Our Ref: BE/110/21/DOC

Part 5 of the Town & Country Planning (Development Management Procedure) Order 2015
Approval of details reserved by condition imposed under ref. BE/135/18/PL relating to
Condition No. 13 (full permission) regarding details of any discharge flows to watercourses;
or for the culverting, diversion, infilling or obstruction of any watercourse on or adjacent to
the Salt Box site.

Land at Salt Box, West of Shripney Road, Bognor Regis

Arun District Council have decided to **REFUSE details reserved by this condition**

Title: UNITS 4, 5 AND 8 DRAINAGE LAYOUT

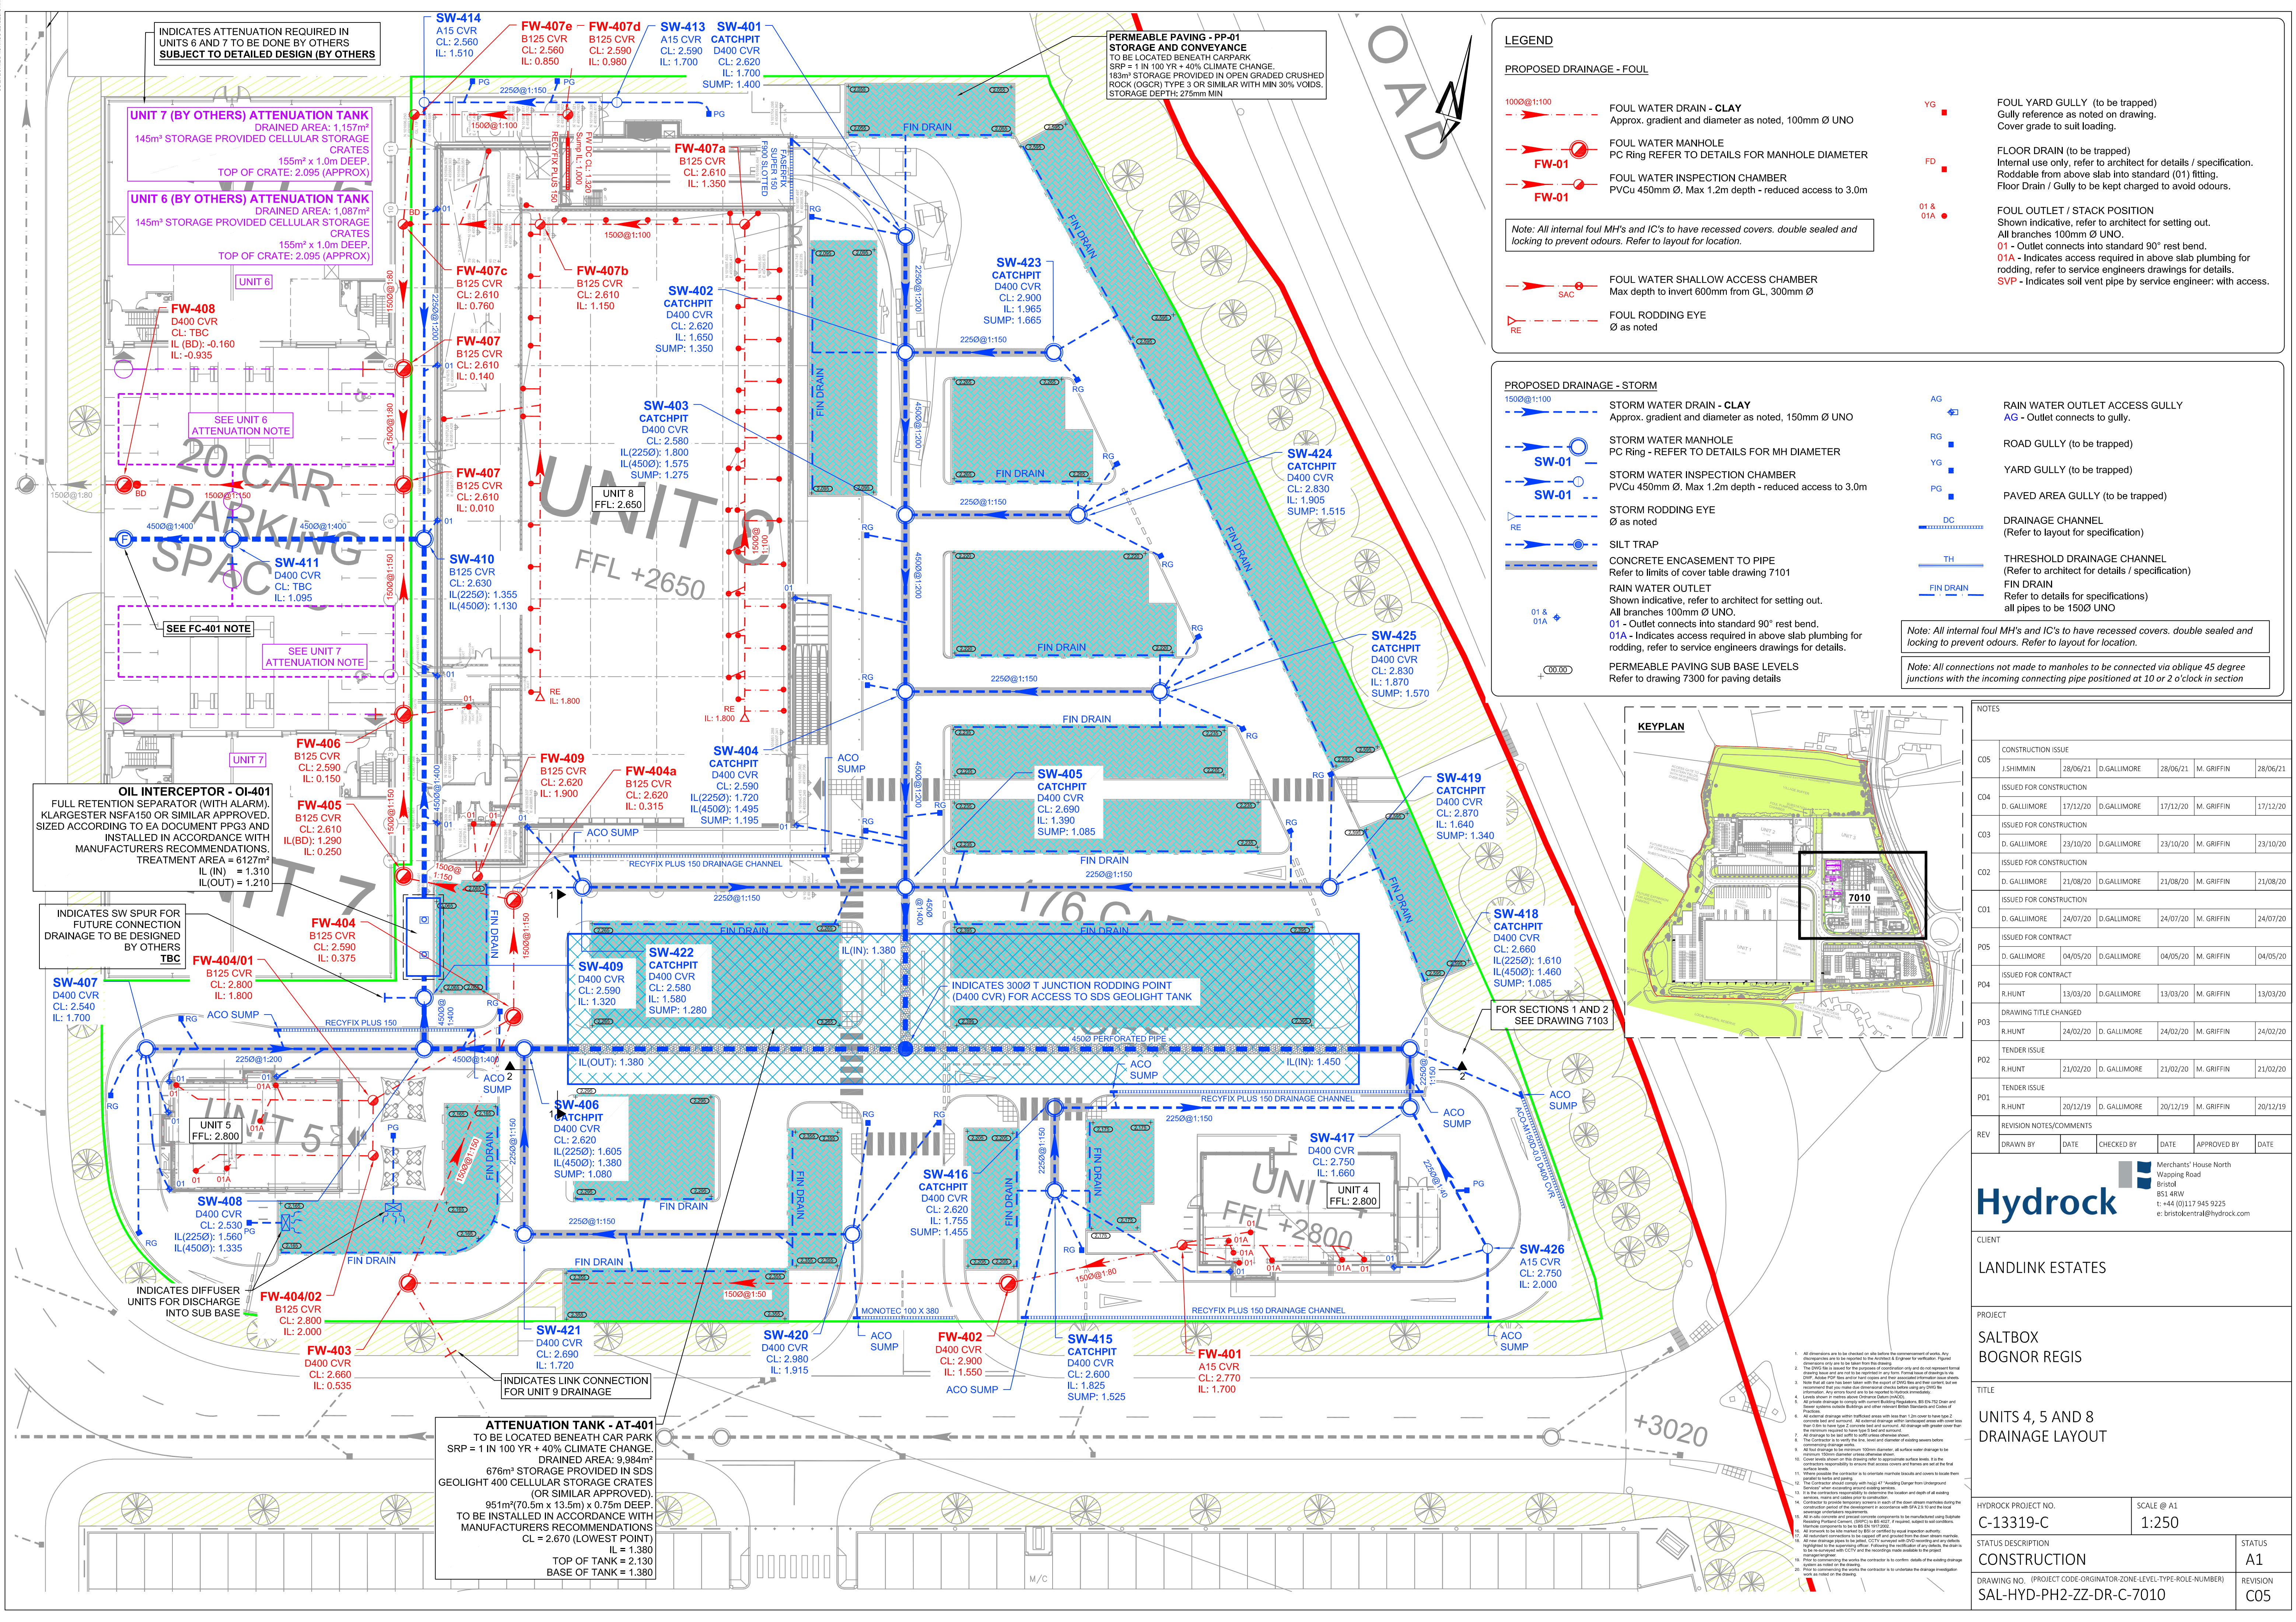
It is evident that substantial changes have been made to the drainage since the approval. A review of these changes has been completed. Levels at some manholes are considerably different between the approved design and as built drawings, the difference in levels is in excess of 50mm in some areas. It appears that at one location an outgoing invert is significantly above the incoming invert to the chamber, and in others downstream inverts are higher than the invert levels of upstream attenuation crates.

Due to the number of discrepancies and the potential significance of these the surface water drainage network would need to be remodelled and updated calculations would need to be provided to demonstrate whether the drainage as constructed meets policy requirements.

Pipe diameters and slopes have not been confirmed. If the fall of a pipe is different over its length, but the distance is the same, the slope of the pipe simply cannot be the same. Gully locations and levels have changed from those designed, gully cover levels have not been labelled on drainage plans.

The type of channel drains constructed are different to that approved. Details of the exact channel drains constructed have not been supplied to evidence that these are suitable for the loading conditions and are appropriately sized to drain their catchment areas.

The headwall angles have been altered since approval. No evidence has been submitted to prove that the relevant consents (FRAP and Land Drainage Consent) apply to the revised headwalls.

The information presented is insufficient to evidence that the as-built drainage meets policy requirements, contrary to Policy W DM2 and Policy W DM3 of the Arun Local Plan and the National Planning Policy Framework.
